**Our Case Number:** ACP-323972-25

**Re:** Public realm and community infrastructure project on lands in Ardee, Co. Louth  
Ardee, Co. Louth

## Re: Submission Ardee 2040

Appendix 3: Proposed Car Parking Provision

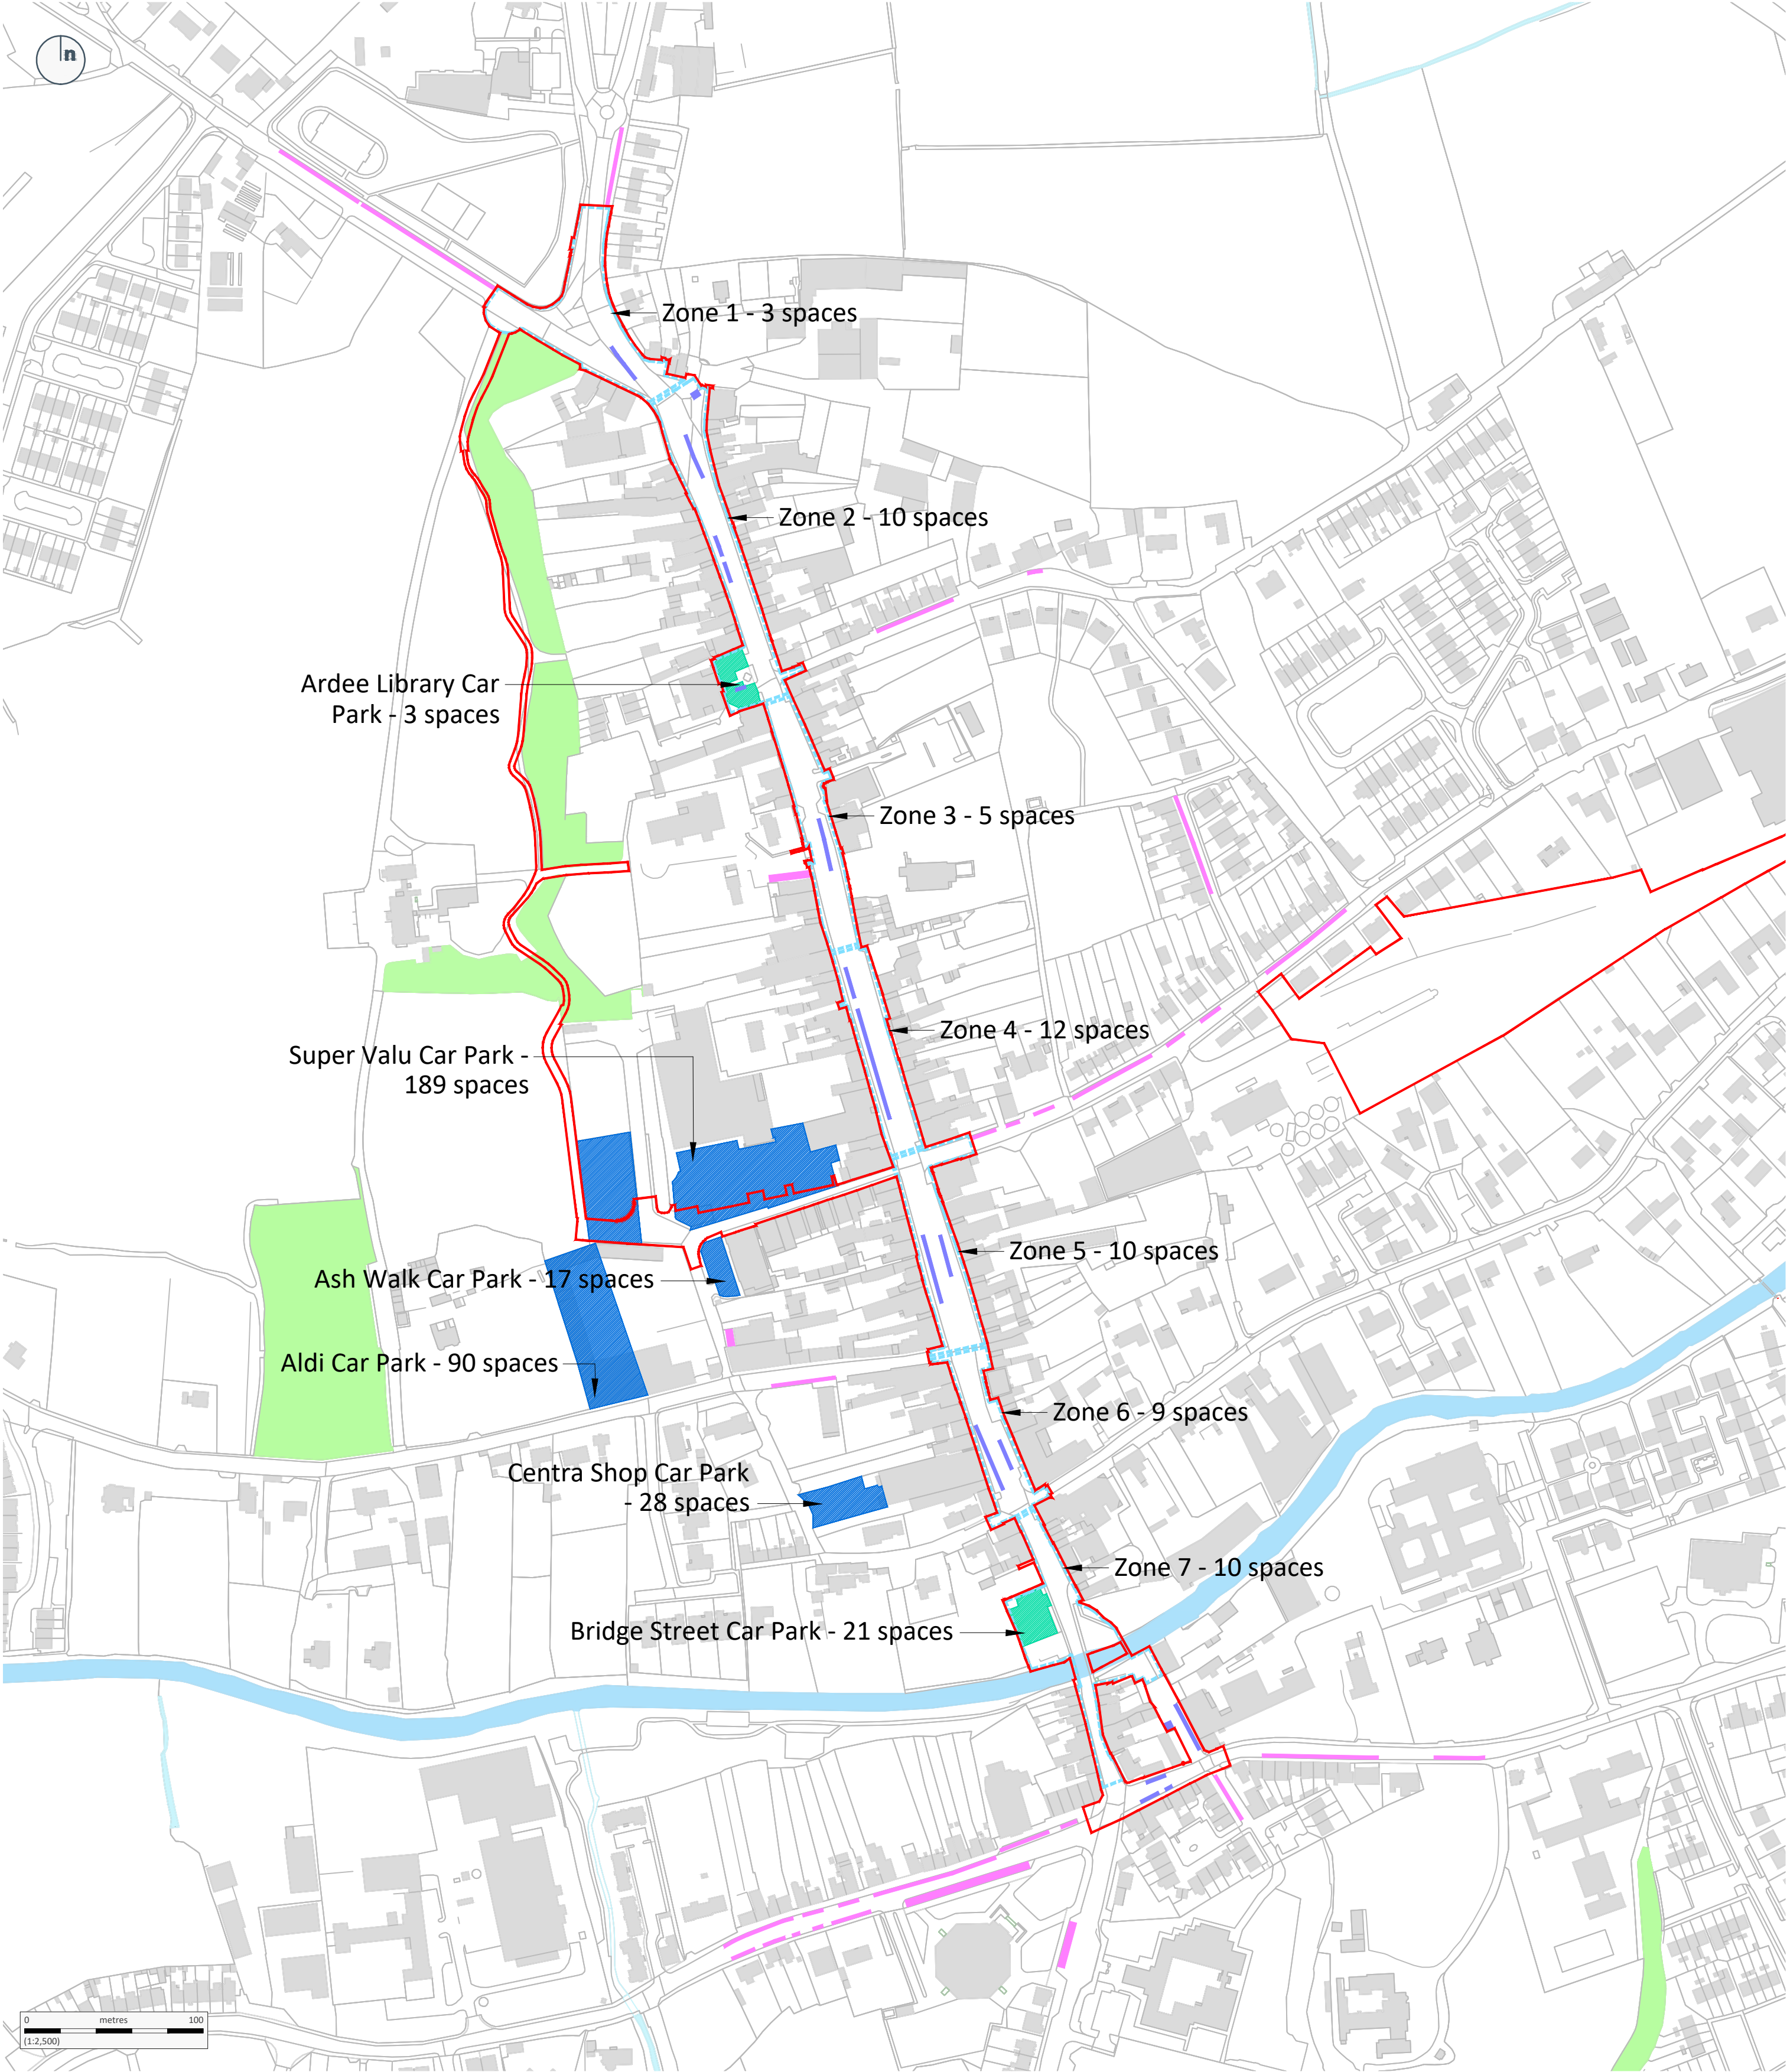
My main concern is in relation to the proposed removal and therefore loss of 150 on street parking places. I am concerned the proposed removal of these parking places did not give due consideration to the economic impacts to the town of Ardee.

While I am fully supportive of the aim of Ardee 2040 to rejuvenate the town of Ardee, the plan to remove this volume of parking places on the main street could prove detrimental to local businesses.

It is vital this plan must provide consideration to the businesses on the Main Street of Ardee, and ensure the parking is not lost as a result of the development of this plan. Ardee is a town that utilises its car parking spaces, and therefore the removal of spaces that are being used on a daily basis is in my opinion not the right decision. The aim of the Ardee 2040 project is to rejuvenate the town, and bring more life into the town however removing the majority on street parking will likely prove counterproductive and discourage individuals visiting the town.

I would urge that serious consideration is given to prevent the removal of the loss of street parking in the town of Ardee, to prevent irreversible damage to businesses in Ardee. I would encourage that a suitable and balanced alternative is investigated to allow for the plan to progress but not with the loss of such a volume of on street car parking.
